# transcript\_ISH2\_session3\_01122022

Examining authority has identified that three substantial structures are proposed as part of the proposals and for the benefit of everyone present. These comprise the bidet crossings at trackback, Kringle back, and more back.

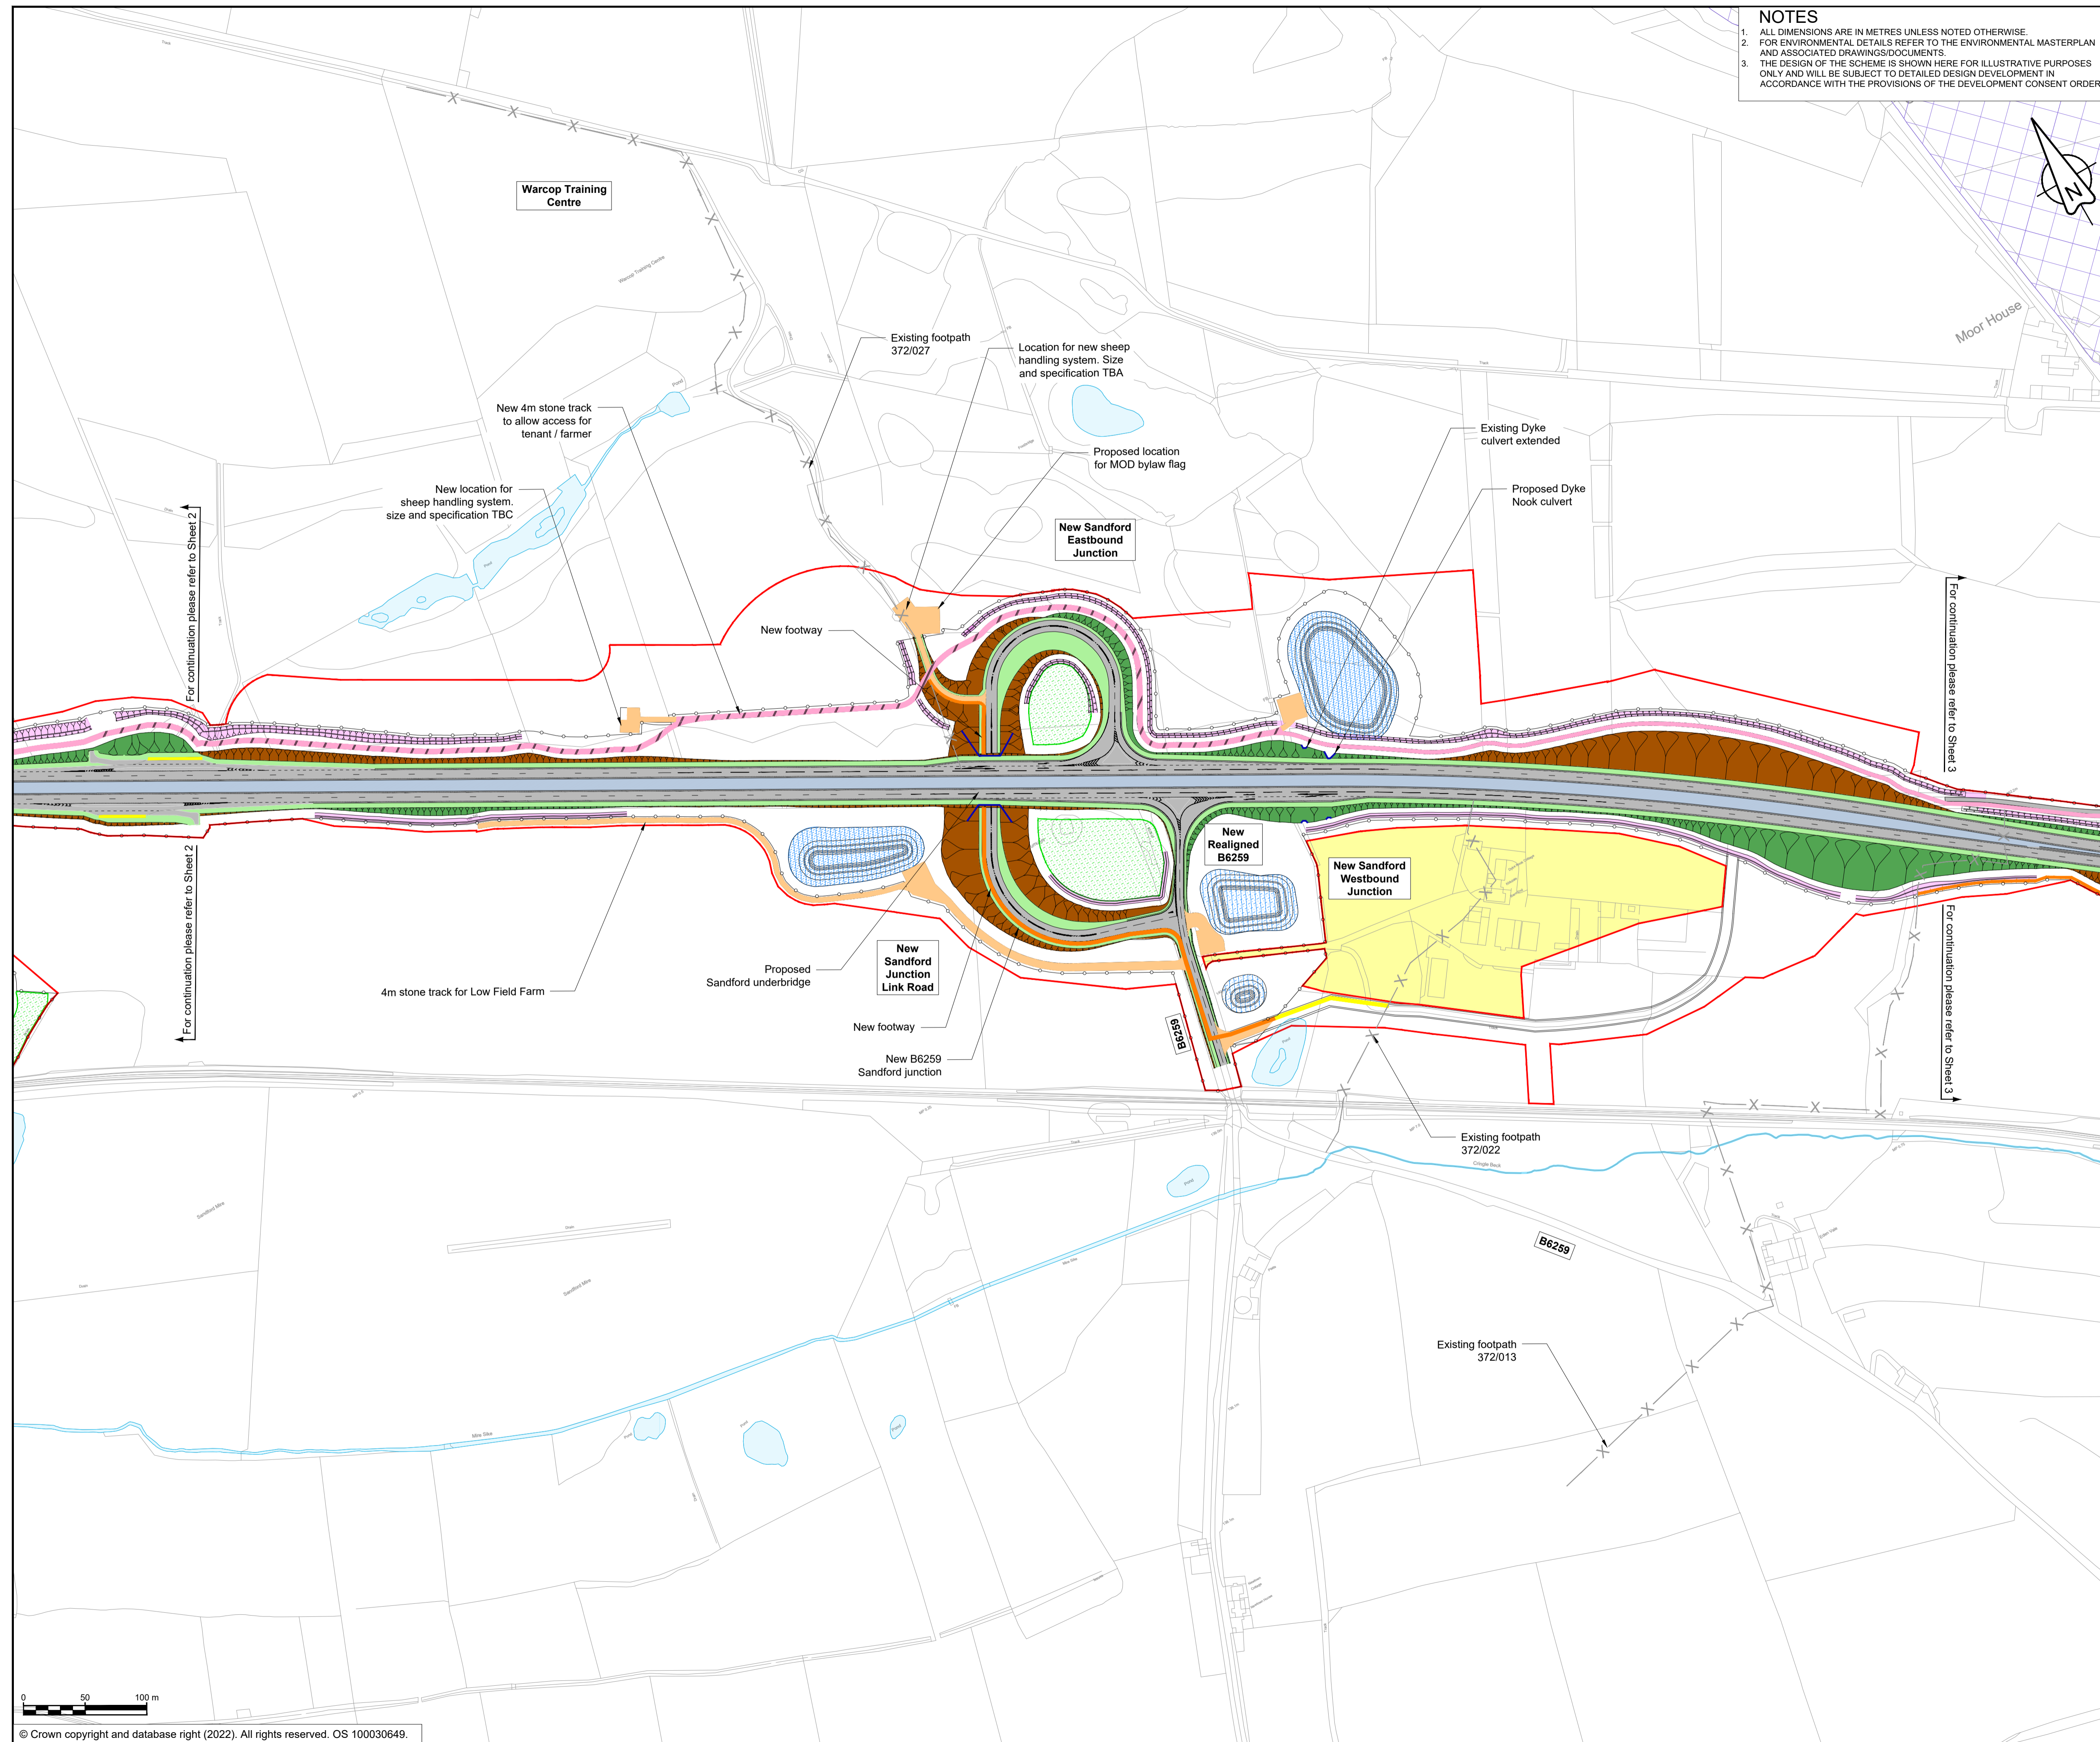
If we can turn now to the general arrangement plan scheme 06. So that's a p p 01. For sheet three please

So following the site visit and after some consideration we would like to request a new viewpoint and photo montage from the public

the public footpath at the rear of Wheatsheaf farm and that footpath reference for your reference is 372 forward slash 014 And that's looking sight words

and that will be looking towards the Kringle back

Again, what we're requesting is an additional viewpoint and photo montage from the footpath reference 372. Forward slash zero to one on the footpath looking southwards towards the moorebank viaduct crossing.

Once again, can I just ask the applicant to confirm that they are happy to prepare an additional you point and photo montage from that location Thank you. It may be useful for us to confirm in our posts
